CITY OF ALBUQUERQUE

January 11, 2016

**Re: Heritage Market Place
1820 Unser Blvd., NW
Request for Temporary Certificate of Occupancy- Transportation Development**
Engineer's/Architect's Stamp dated 4-9-15 (H09-D024)
Certification dated 1-04-16

ENGINEER'S SEAL	HERITAGE MARKET PLACE ALBUQUERQUE, NM	DRAWN BY pm
		DATE 2-17-15
		DRAWING 2014038-SPC
		SHEET NO SP-1
RONALD R. BOHANNAN P.E. #7868	TIERRA WEST, LLC 5571 MIDWAY PARK PL. NE ALBUQUERQUE, NEW MEXICO 87109 (505) 858-3100 www.tierrawestllc.com	JOB # 2014038

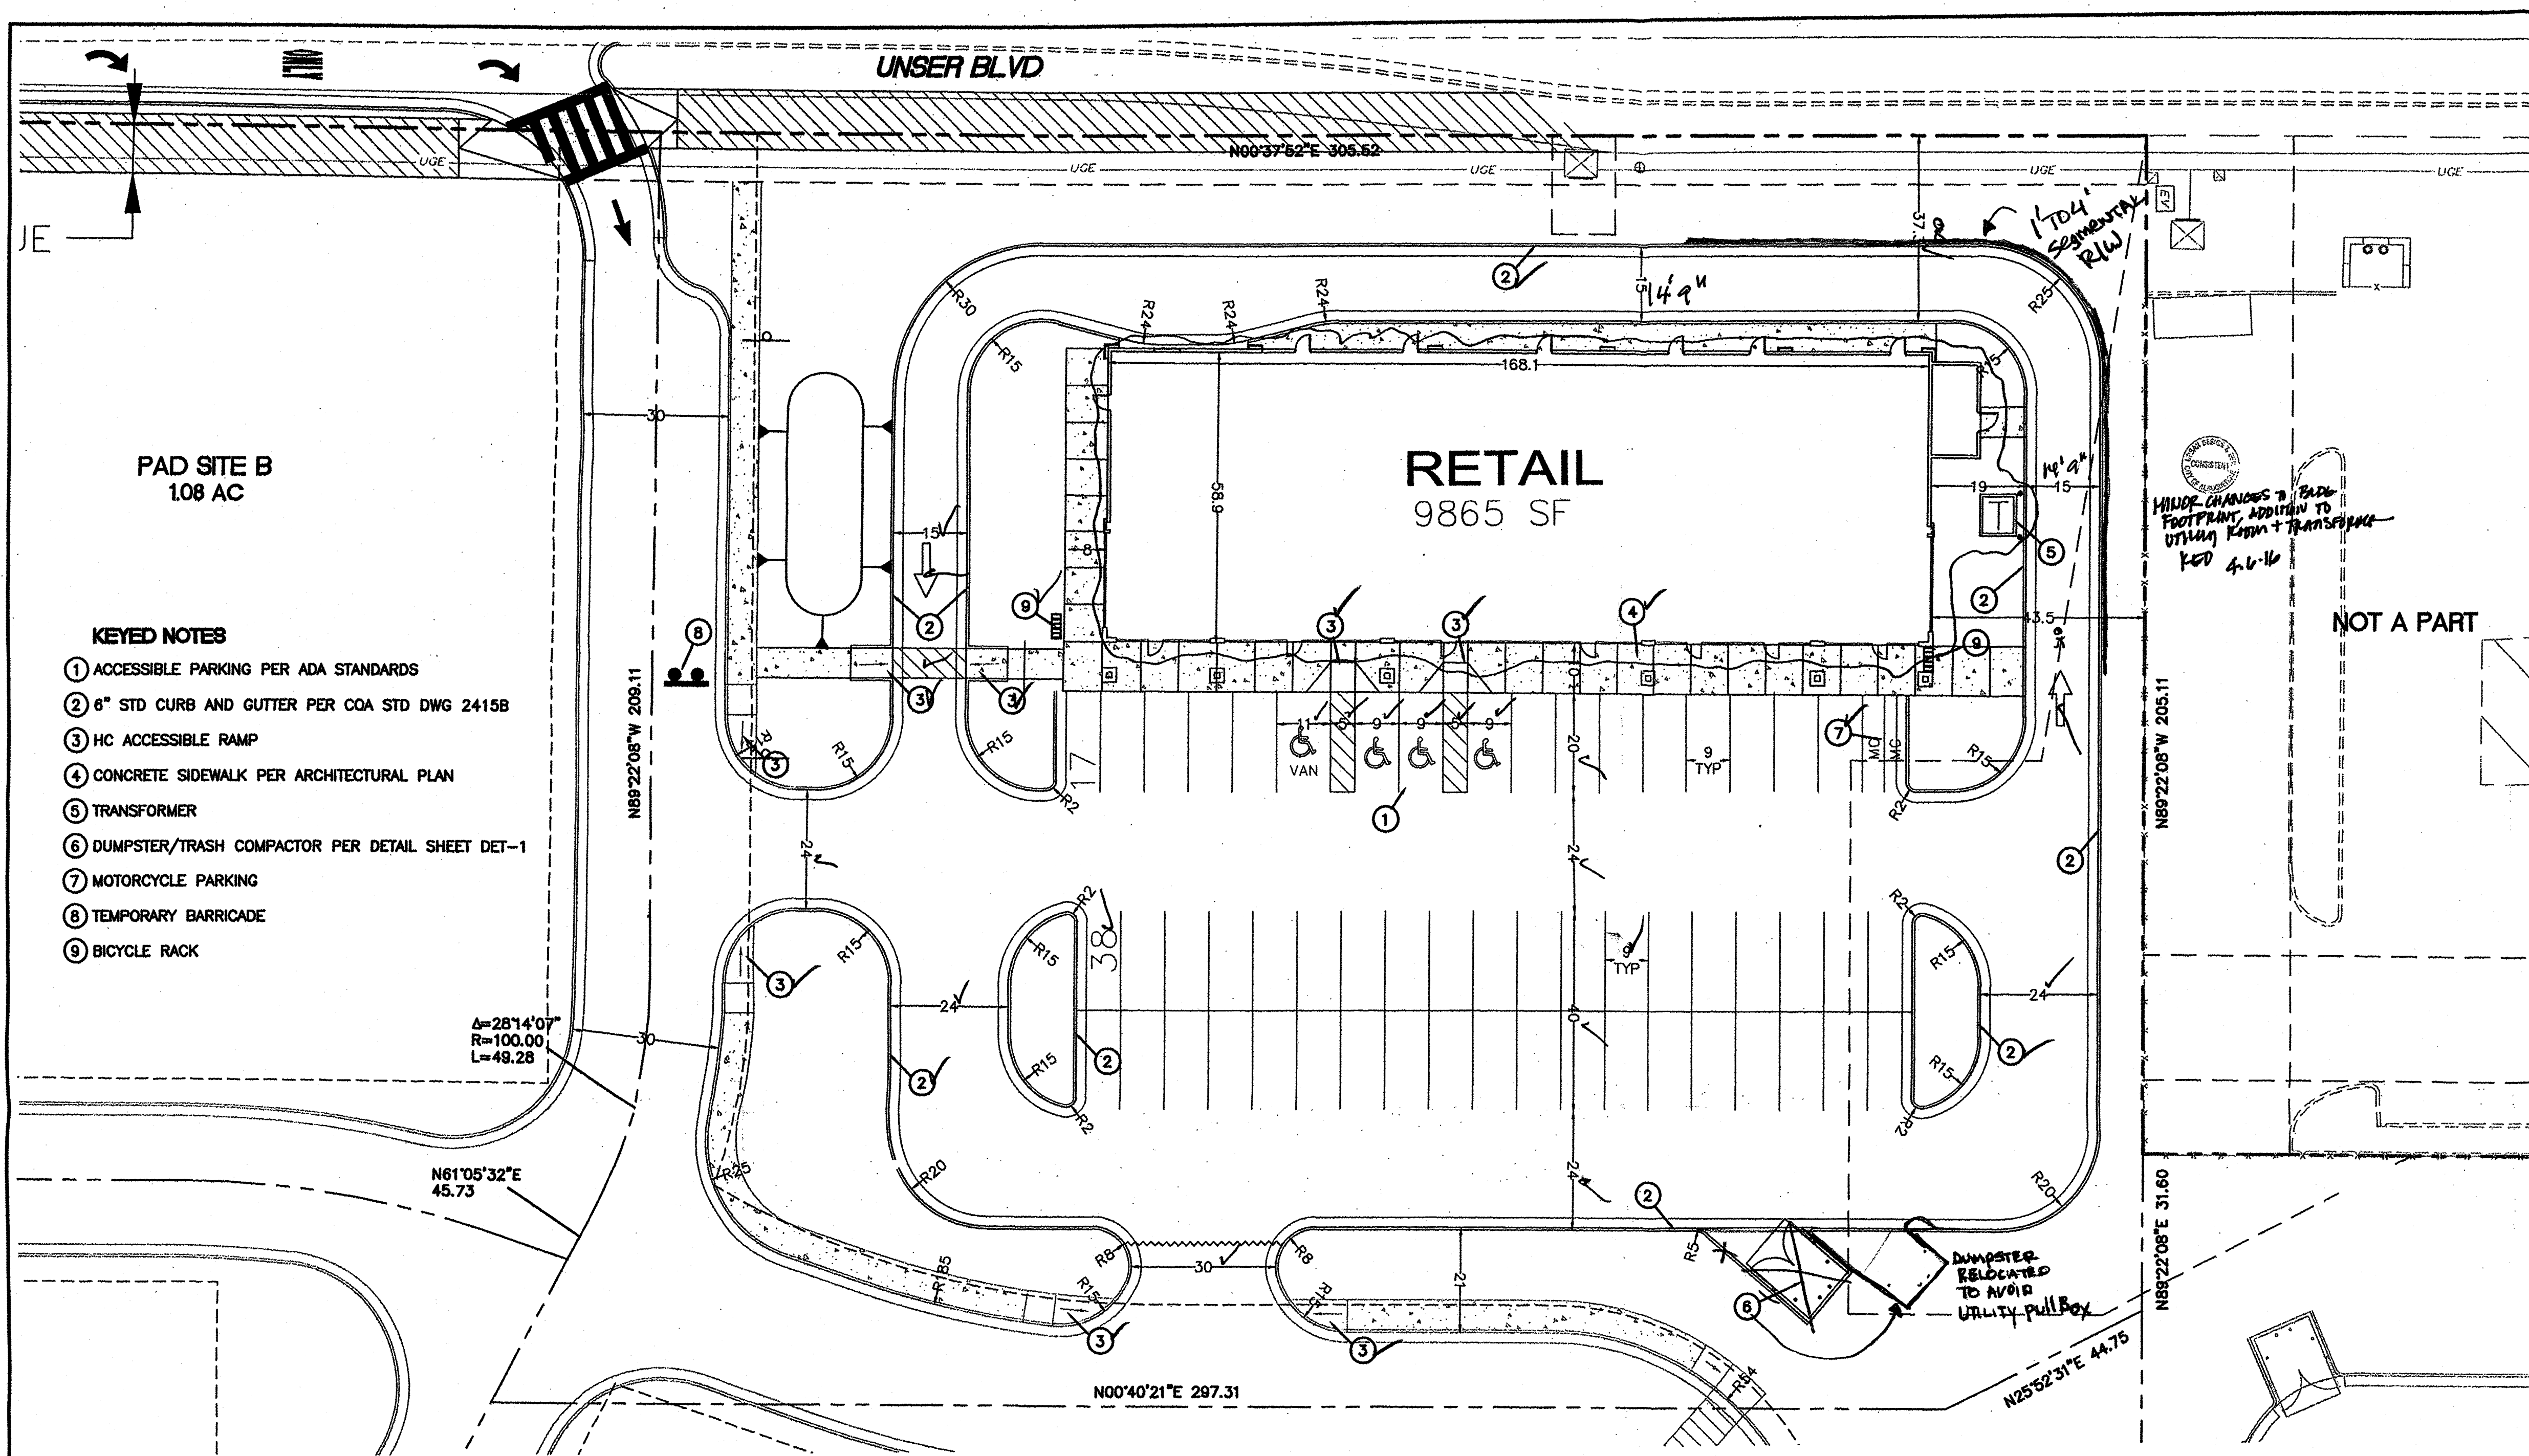
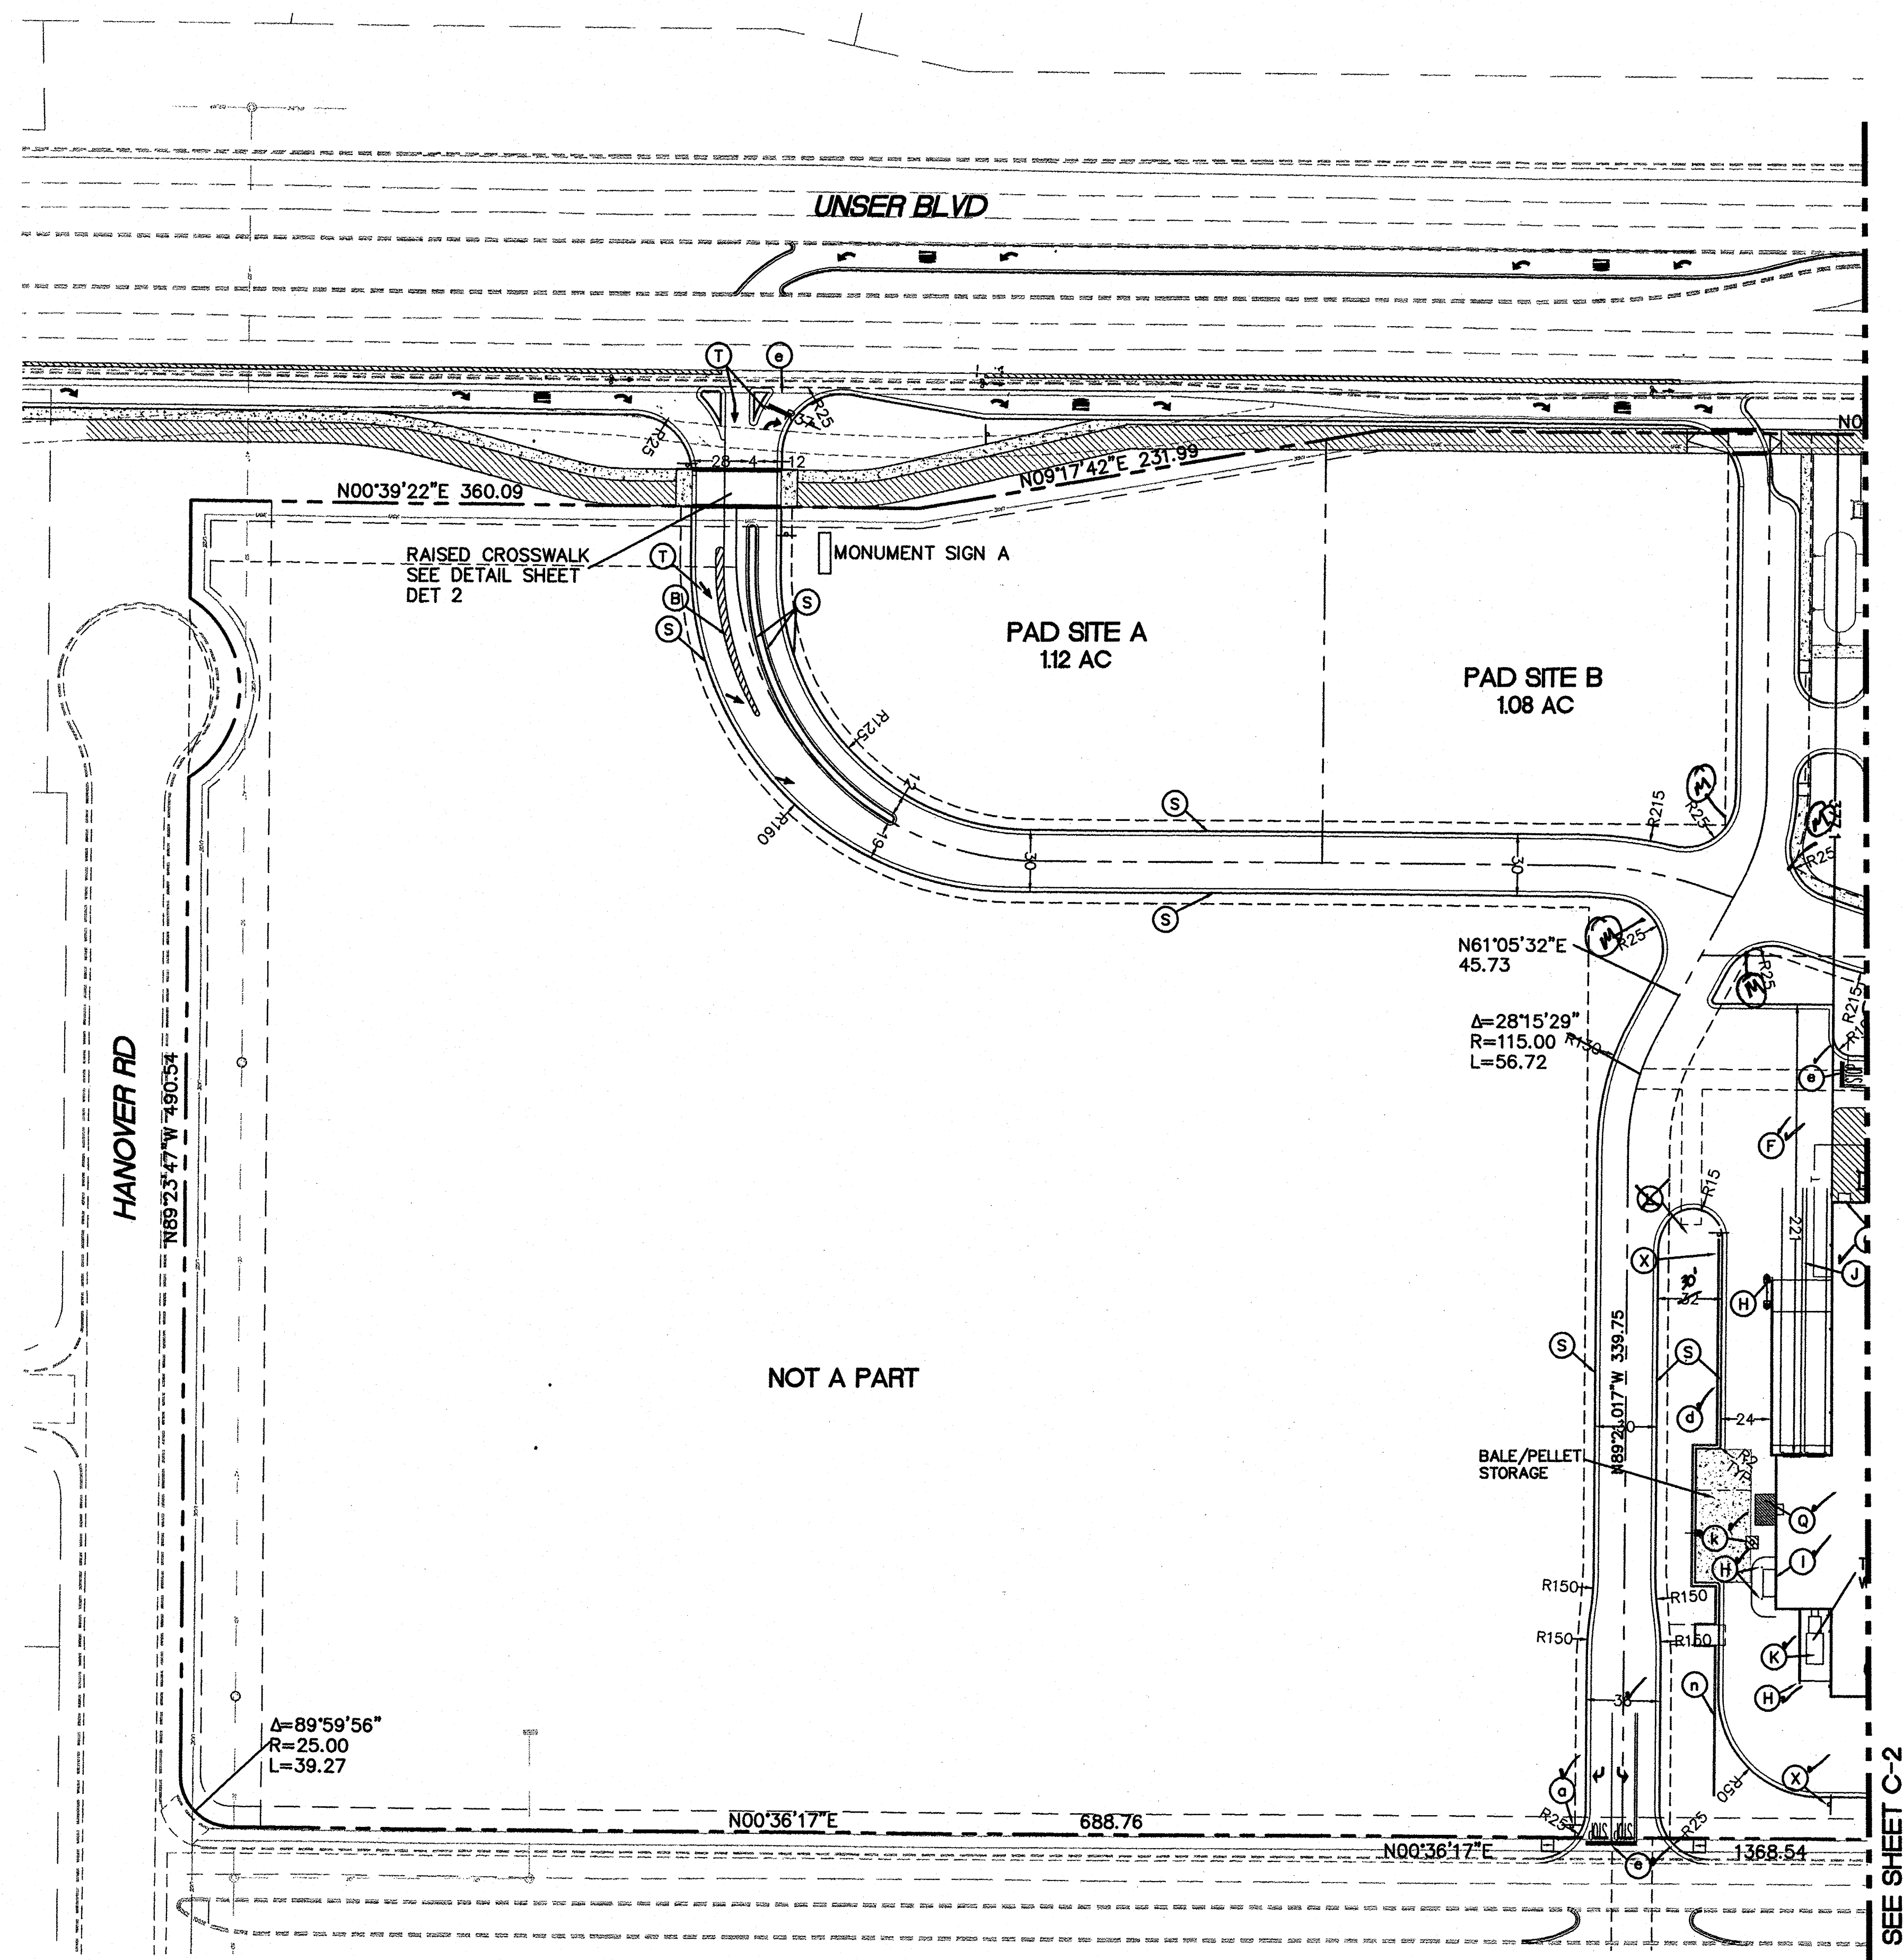
1. Truncated domes along all public Right of Ways need to be installed.
2. ADA parking spaces do not meet number of required spaces. ADA pavement between ADA parking spaces needs to be marked with cross hatching.
3. Motorcycle parking is missing and required.
4. "No Trucks" sign Key Note "K" needs to be installed at the eastern entrance.
5. Painted "Yield" on pavement on the north side of store needs to be repainted, due to discoloration.
6. Work Order must be complete and accepted prior to final C.O.

Please note that Certification of Site Plan for Building Permit needs to reflect date drawing was signed by D.R.B Chairperson, which was 4-9-15 for this project.
